Castle Hill & Hills District Agricultural Society Inc.

APPLICATION NUMBER SSI-5100

North West Rail Link Environmental Impact Statement 1 - Submission

Figure 5 Hills Centre station – heavy vehicle routes

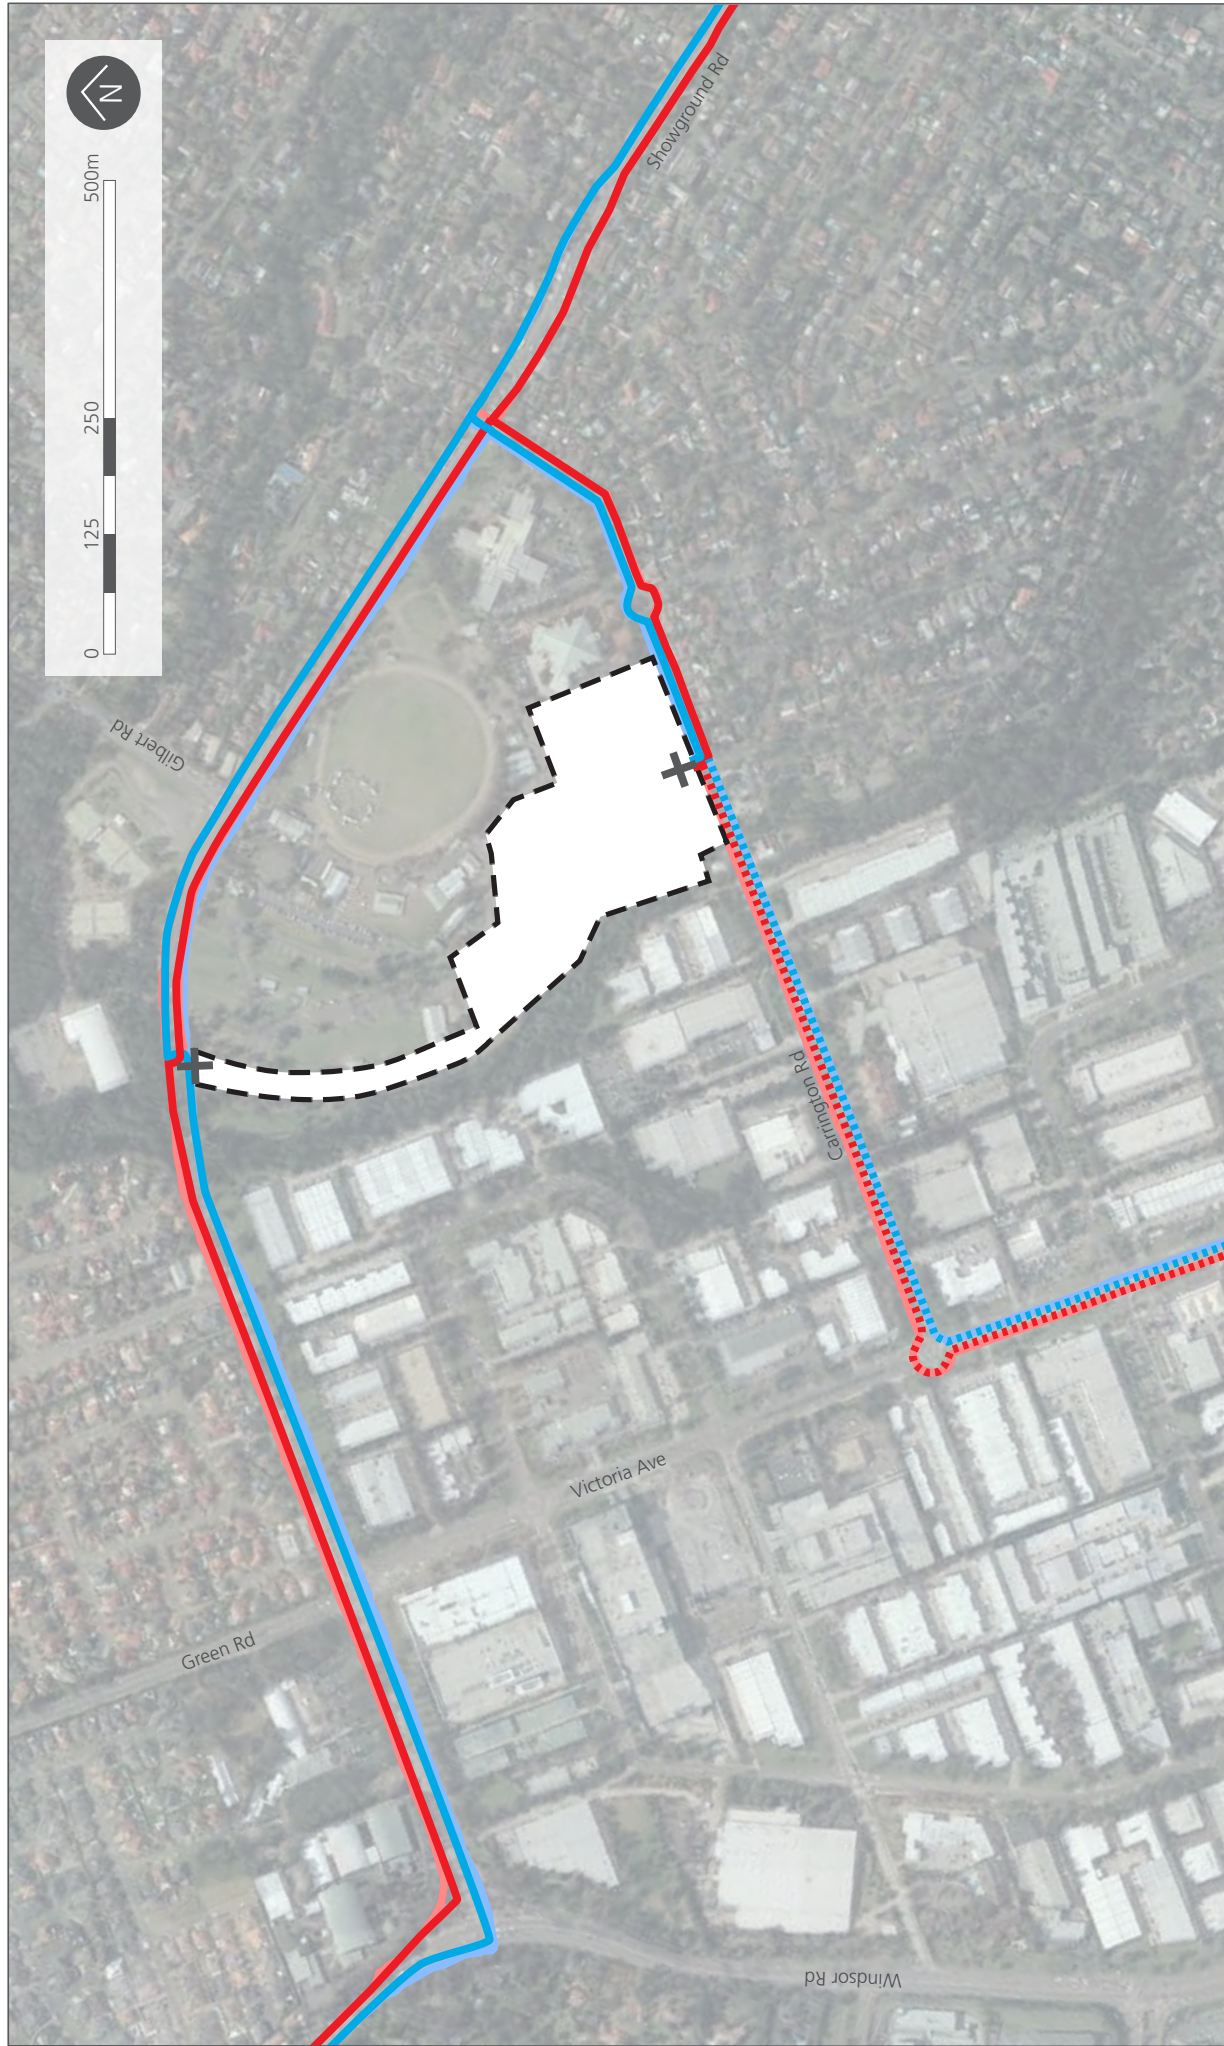
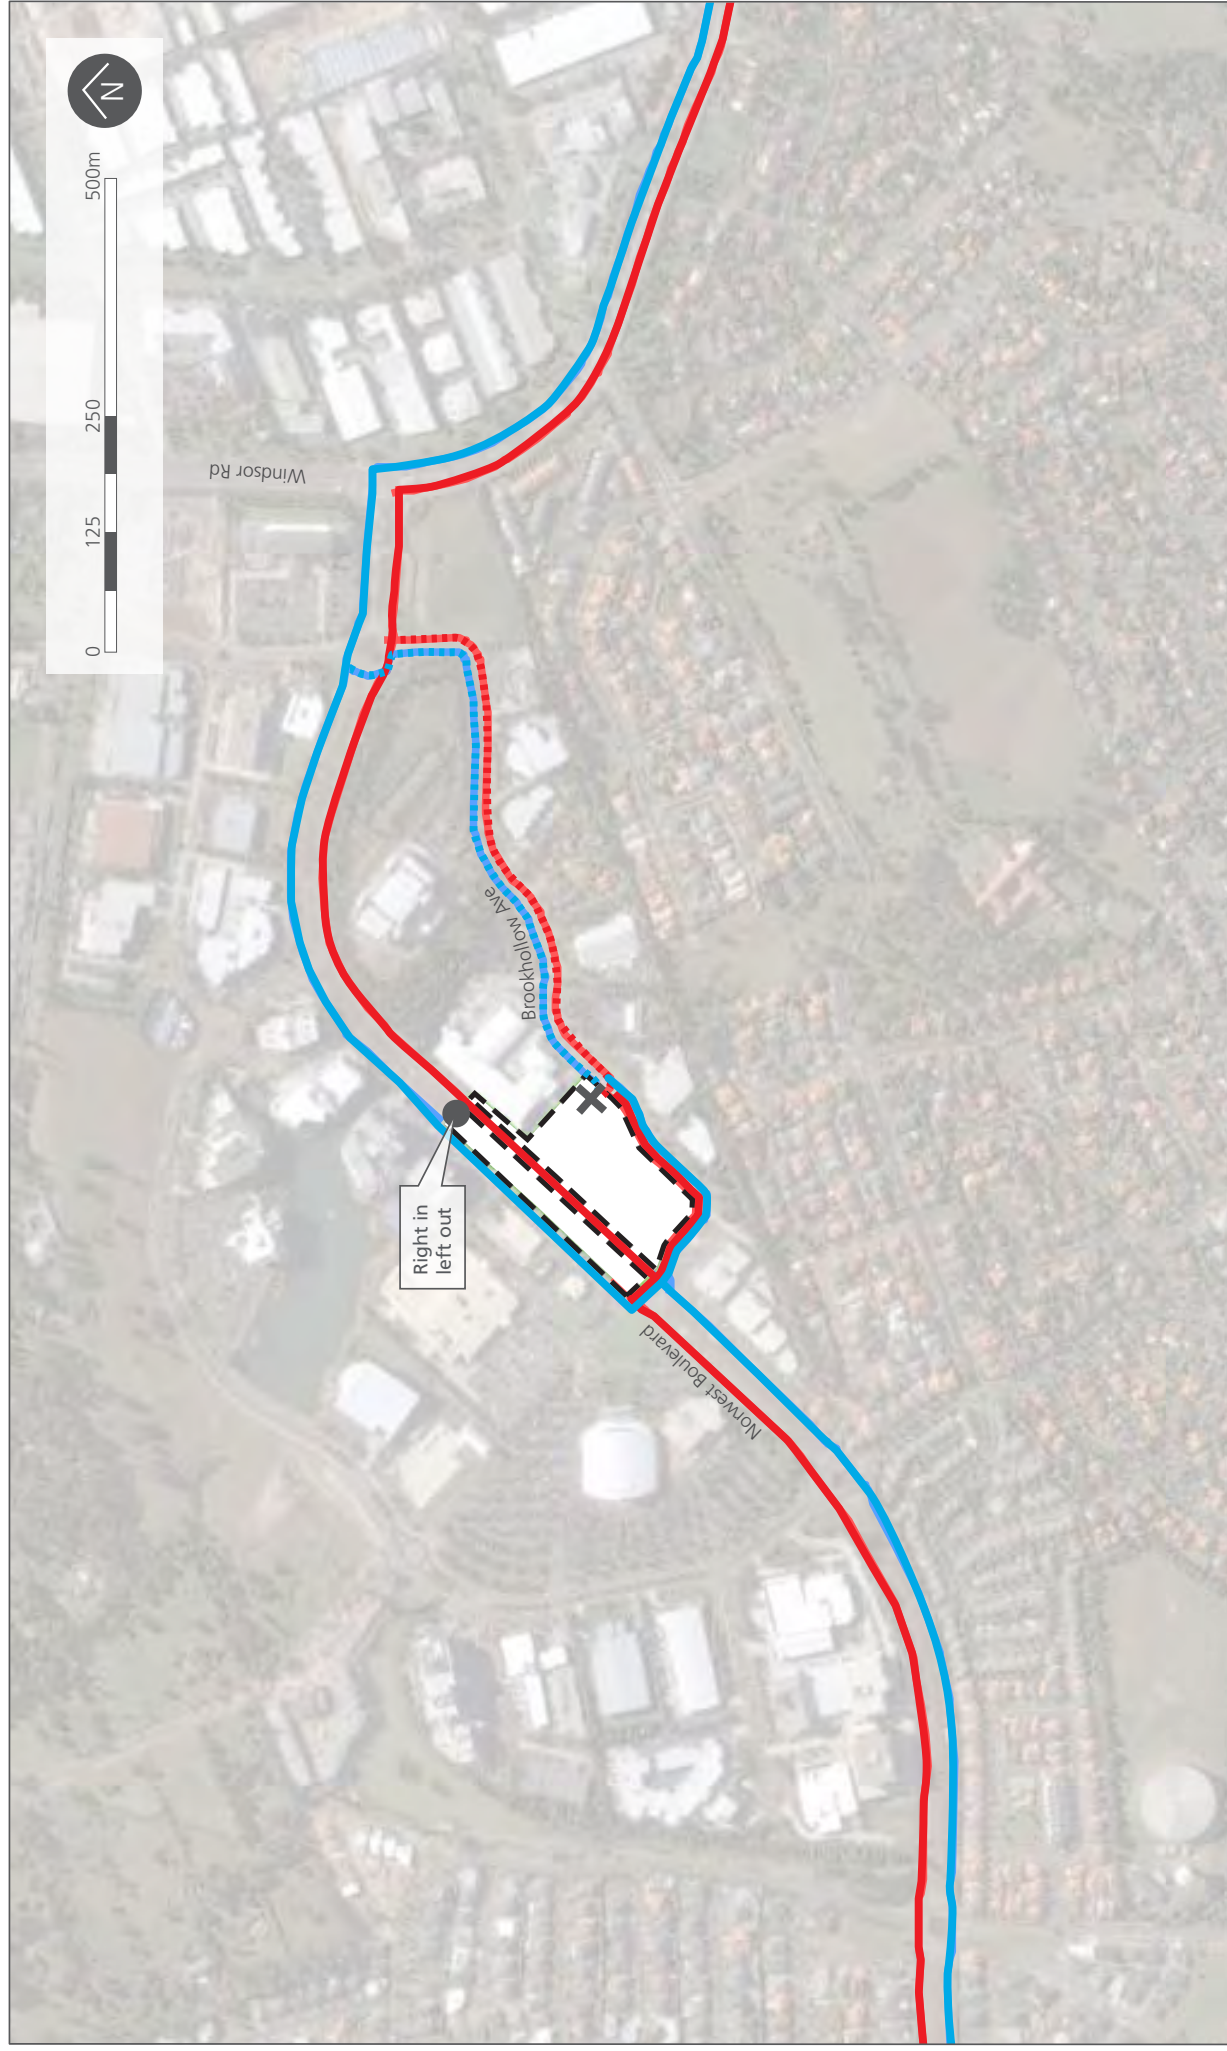
The EIS documentation indicates access to the Showground will be off Showground Road. This section of Showground Road is a very congested arterial road with no access to any other development between Carrington Road and Victoria Avenue. Therefore the Society cannot support this proposal and requests that a separate access should be provided off Carrington Road between the construction site and The Hills Centre.

- Regarding alternative access to the showground, has the project team considered option of a bridge access from the showground to Anella Ave/Salisbury Road over Cattai Creek? This would be a bridge (orange shaded area) to take spoil out during the construction phase and left after the project is completed. This could then be used as the alternative access by users of the showground and alleviate obvious problems with access to Showground Road at the bottom of a dip of a heavily used road.

Has an alternative to the haulage road through the showground been considered using a conveyor system across Cattai Creek, between factories, to trucks in Anella Ave/Salisbury Road.
